You will need to revise your landscaping to meet the standards of LDC Sec. 6.2.2. Since it does not make sense to landscape the entire property, you will at a minimum need to landscape the project area according to LDC standards. This will require a request for alternative landscaping at the site development plan stage.

Landscaping Plan

Overall Site	Sheet
9/15/2020	L101
Scale: 1/8" = 1'-0"	DATE PLOTTED:

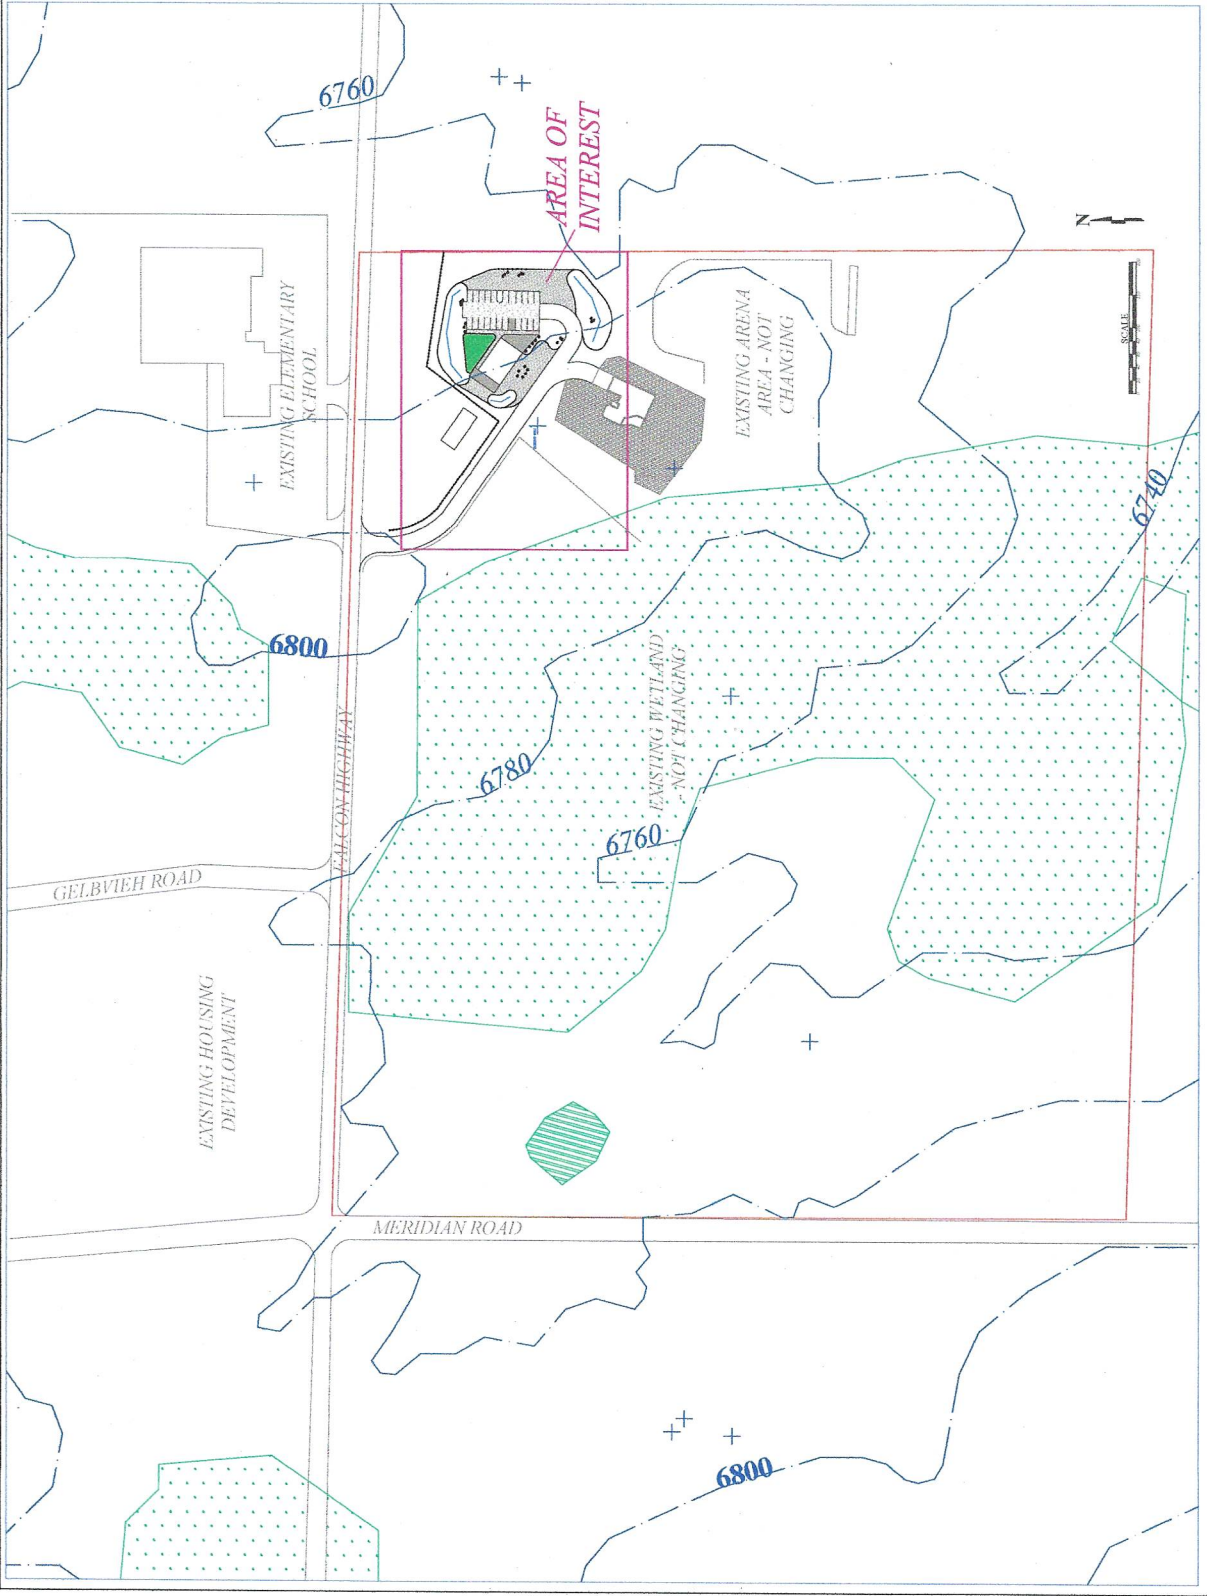
At a minimum, you will need to provide screening measure for the following:

- the parking area, meeting Sec. 6.2.2(C)
- buffer the project boundary area, meeting Sec. 6.2.2(D)(2) on the east side of the project
- Internal landscaping to the project area, meeting Sec. 6.2.2(E)(2).

You may need to request alternative measures for a perimeter screening fence or wall, but it may still be beneficial to screen portions of this site with an opaque fence or wall.
